Ribble Valley Borough Council
Council Offices
Church Walk,
Clitheroe
Lancashire
BB7 2RA

Phone: 0300 123 6780
Email: Kathryn.Walsh@lancashire.gov.uk
Your ref: 3/2025/0183
Our ref: 3/2025/0183/HDC/KW
Date: 10 April 2025

Location: Avondale Sawley Road Grindleton BB7 4QS
Proposal: Proposed second storey extension with solar panels to bungalow, front porch, single storey rear extension, detached garage to front of property, detached summer house to rear garden.
Grid Ref: 376051 445550

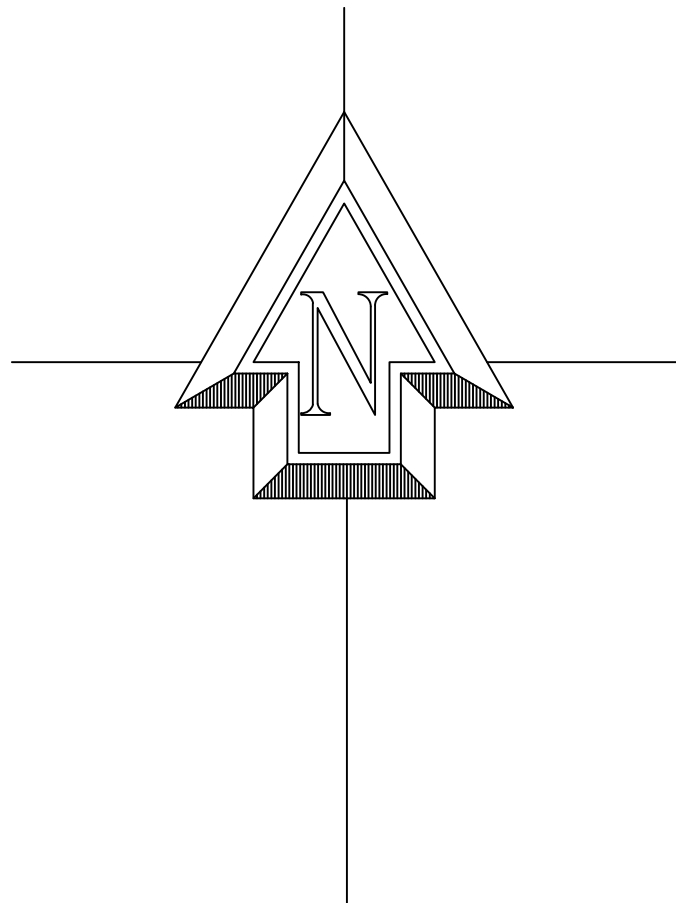
However the proposed garage is situated 1.5m from the highway boundary and as such the LHA has concerns regarding visibility along Sawley Road for emerging vehicles from the site and the neighbouring property. The LHA would look for the garage to be repositioned at least 3m into the site to protect the existing visibility splays.

In conclusion, the positioning of the proposed garage raises concerns about visibility along Sawley Road, prompting the requirement to relocate the garage at least 3 metres into the site to preserve the existing visibility splays as such amended plans are required showing the garage set back 3m from the highway boundary.

Proposed alterations at :		
Avondale Sawley Road Grindleton BB7 4QS		
CLIENT:	Mr & Mrs Seed	
DATE:	July 2024	
SCALE:	1:200	
DWG No:	Site plans 4 of 6	
L.A:		
AMENDMENTS:		DATE:
ENTWISTLE DESIGN SERVICES		
7 Edgefield Astley Village Chorley PR7 1XH		Tel:01257 274976 E-Mail entwistledesign@aol.com

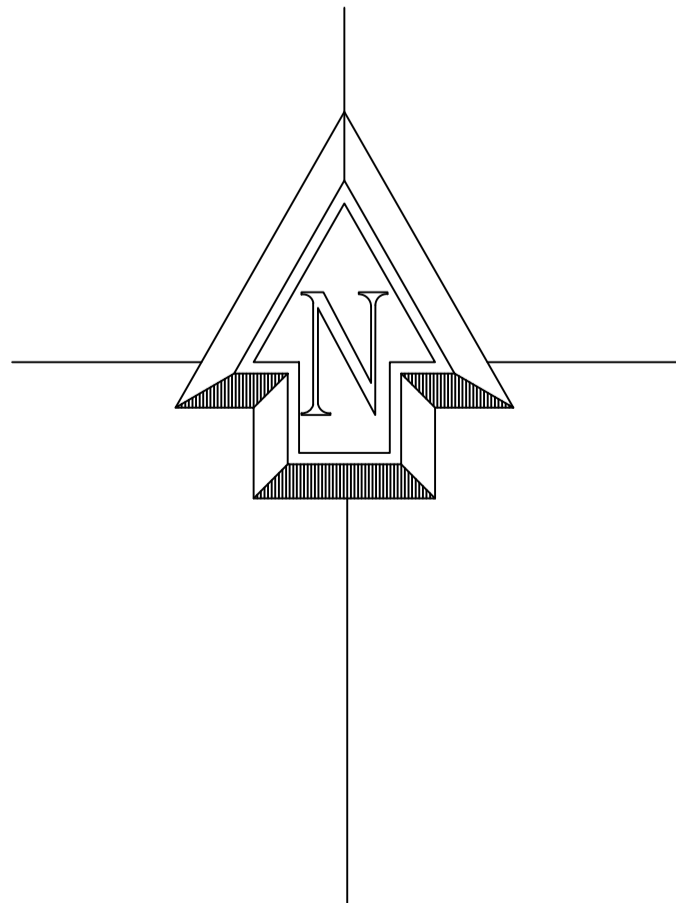
The LHA have reviewed the proposed site plan, Site plans 4 of 6, and are aware that the site access will remain unaltered following the proposal.

The recommended minimum internal dimensions for a double garage size is 6m in length and 6m wide. The recommended distance of 6m is based on the length of a large family car (Ford Mondeo Estate 4.58m long), clearance at the rear of the car (200mm), overhang of the garage door (600mm) and room to stand in front of the car and open/close the garage door (600mm). The LHA has reviewed the garage plan, Summer house & Garage 3 of 6, and note that the garage is approximately 5.7m wide; as such, the LHA are of the opinion that the garage is a suitable width for one vehicle to park.

The LHA has also reviewed the proposed site plan, Site plans 4 of 6, and noted that much of the existing driveway will be retained and provide parking and turning provisions for at least a further 2 vehicles; as such, the proposed 4 bedroom dwelling will have acceptable off-street parking provisions within the site.
